MDDP AMENDMENT & FINAL DRAINAGE REPORT

MERIDIAN ROAD & BENT GRASS MEADOWS DRIVE

DATE:
March 2020
Revised: July 2020

Engineering Review

MERIDIAN ROAD DRAINAGE PLAN

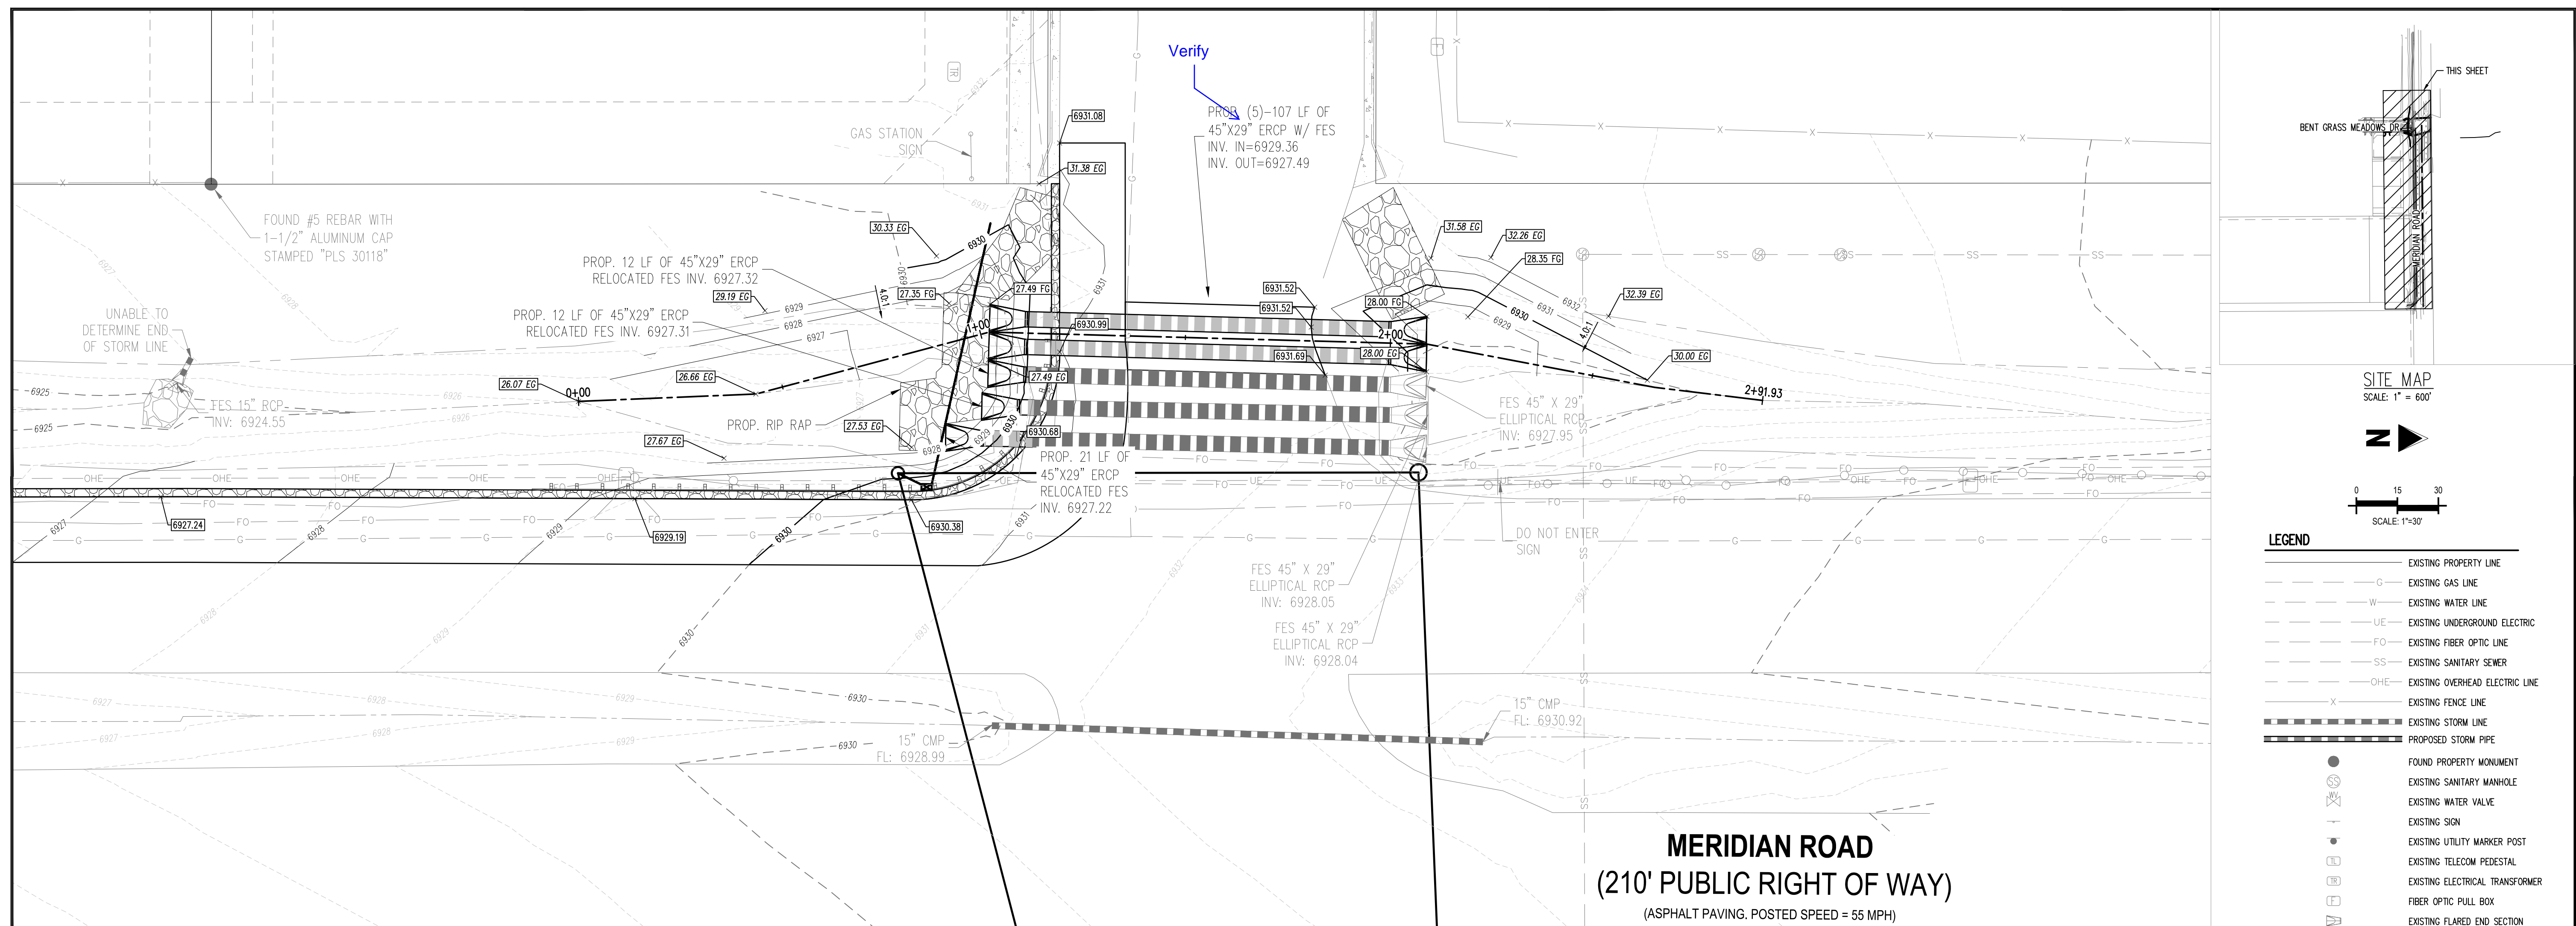
Provide options for a long-term solution -- the channel or pipe necessary (size of both options) to convey developed flows outside of Bent Grass Meadows Drive. If water rights allow for retention describe. State what the allowable capacity of Bent Grass Meadows Drive curb and gutter is along the north side (no overtopping unless it can be shown that flows won't enter the subdivision to the south).

Verify capacity for the total diverted flows.

How many drop structures and what height will be required to obtain this slope? (~12 ft total=> 1 ft per 100 ft between BGMD and Owl Place?)
